CITY OF ALBUQUERQUE

Re: Shell Building @ Los Lomas
2101 Vista Oeste NW
Traffic Circulation Layout
Architect's Stamp **10-20-2017** (H10-D031)

Based upon the information provided in your submittal received 10-20-17, the above referenced plan cannot be approved for Building Permit until the following comments are addressed:

1 Architectural Site Plan
Scale: 1"=30'-0"

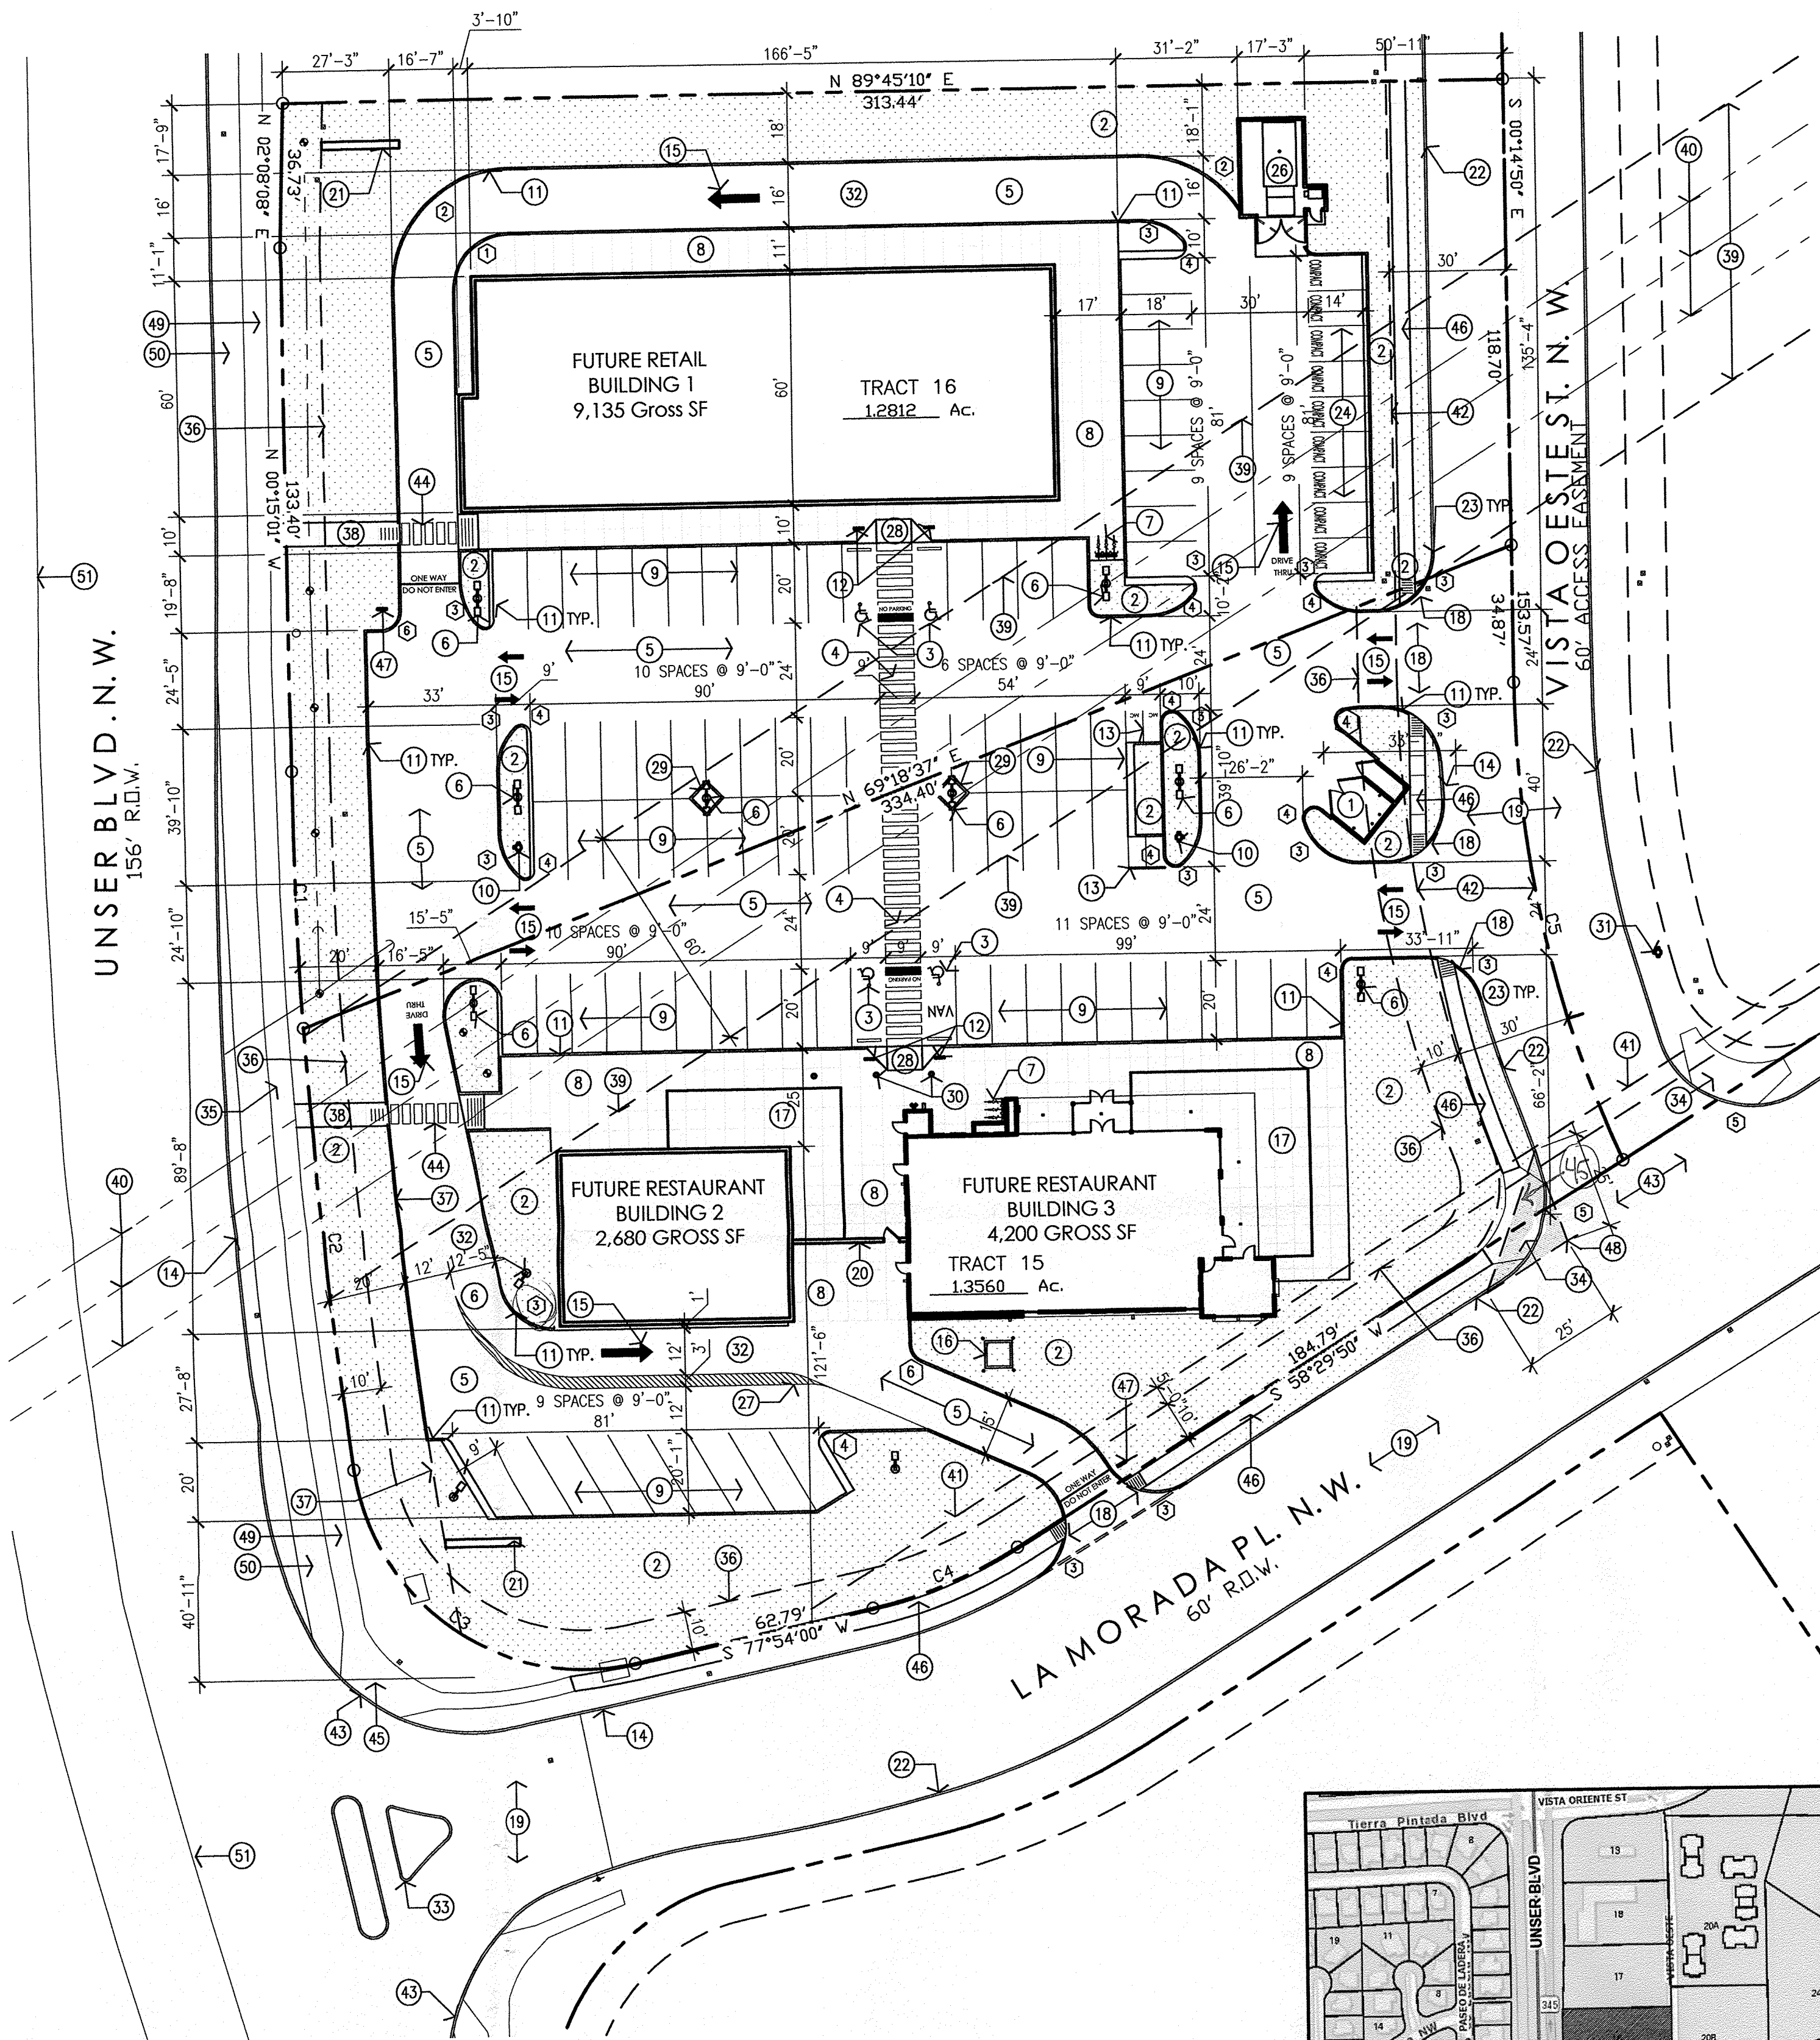
1. A scale of 1"=20' is recommended for sites less than 5 acres.
2. Please show a vicinity map showing the location of the development in relation to streets and well known landmarks.

3. Identify all existing access easements and rights of way width dimensions.
4. Identify the right of way width, medians, curb cuts, and street widths on adjacent streets.

5. List radii for all curves shown; for passenger vehicles, the minimum end island radius for passenger vehicles is 15 ft. Radius for delivery trucks, fire trucks, etc. is 25 ft. or larger.

6. ADA curb ramps fronting the site must be updated to current ADA standards and have truncated domes installed.
7. Per the zoning code, a 6 ft. wide ADA accessible pedestrian pathway is required from the public sidewalk to the building entrances. Please clearly show this pathway and provide details.

8. Sidewalk shall be required along the properties frontage. Sidewalk should be 4 feet wide along La Morada Pl and Vista Oeste. All sidewalks along streets should be placed at the property line.

9. One-way vehicular paths require pavement directional signage and a posted "**Do Not Enter**" sign at the point of egress. Please show detail and location of posted signs.

10. Show the clear sight triangle and add the following note to the plan:
"Landscaping and signage will not interfere with clear sight requirements. Therefore, signs, walls, trees, and shrubbery between 3 and 8 feet tall (as measured from the gutter pan) will not be acceptable in the clear sight triangle."
